## DEVELOPMENT REVIEW BOARD

### Planning - Case Comments

**Project Name:** MDS Innovation Park II

**Request:** Alternative Landscape Plan

**OVERALL
 ALTERNATIVE
 LANDSCAPE PLAN**

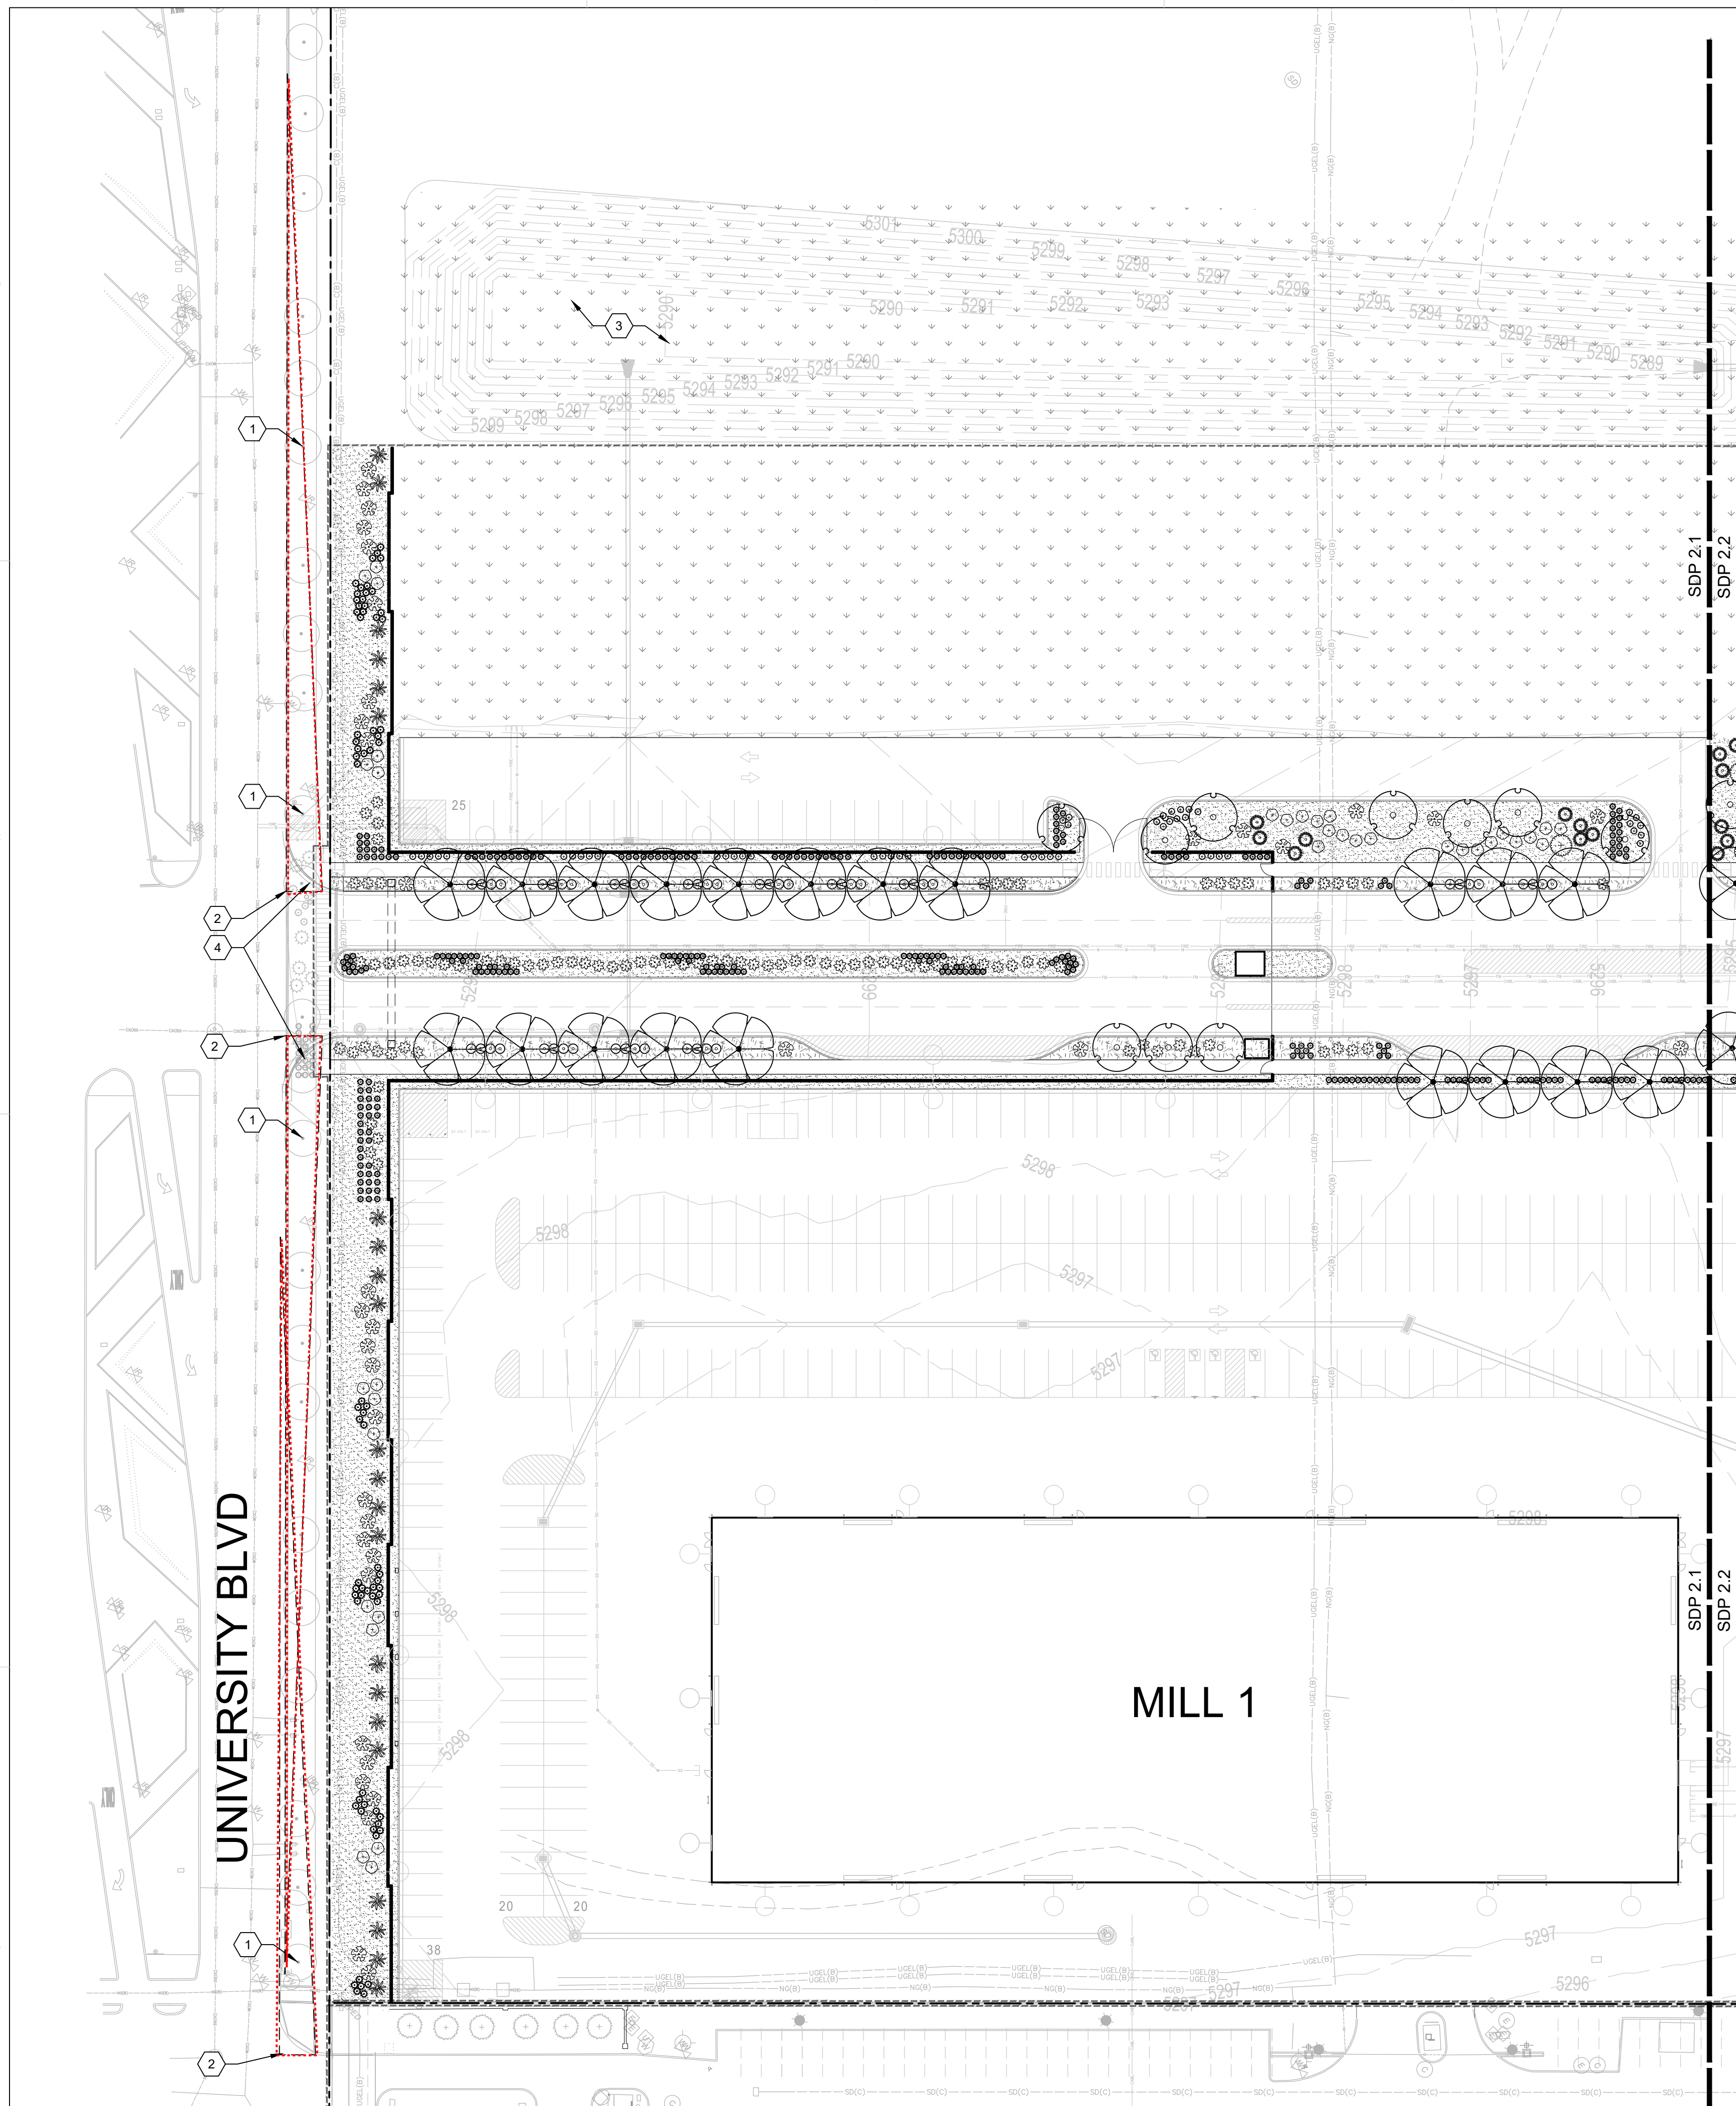
- The Alternative Landscaping Plan is compliant with the overall intent of Section 5-6 of the IDO. (All following comments were addressed on the Alternative Landscaping Plan). **However**, the Alternative Landscape Plan submitted July 11, 2023 is missing landscaping that the previously approved Alternative Landscape Plan **2/24/2022 (PR-2021—005573) and 11/29/2021 (PR-2021—005629)** had featured. The following areas were landscaped on the previously approved Alternative Landscape Plan and are not showing landscaping on the proposed Alternative Landscape Plan:

1. Production Office 2
  2. Stages 17 & 18 (previously Stages 19 & 20).
  3. Southeast of parking area southeast of Stage 17 & 18.
  4. Stages 19 & 20 (Previously Stages 15 & 16).

5. Stages 15 & 16 (Previously Stage 12 & Stage 14).
  6. Stages 17 & 18 (Previously Stages 19 & 20).
  7. Trees southeast of Backlot B.
  8. East of roadway at Production Support Centers.

9. West of Backlot A along road.
  10. South of Backlots A & B in islands.
  11. East of Mill 3 (previously Mill 2).
  12. South of Production Support Services.

- Areas that have additional landscaping that was not shown on the previously approved Alternative Landscape Plan are the following:
  1. Island between Stages 15 & 16 and Stages 19 & 20 has additional landscape in the proposed Alternative Landscape Plan.

2. There is an increase in trees south of Existing Mill 2 and Existing Stage 9 on the proposed Alternative Landscape Plan submitted for review July 11, 2023.
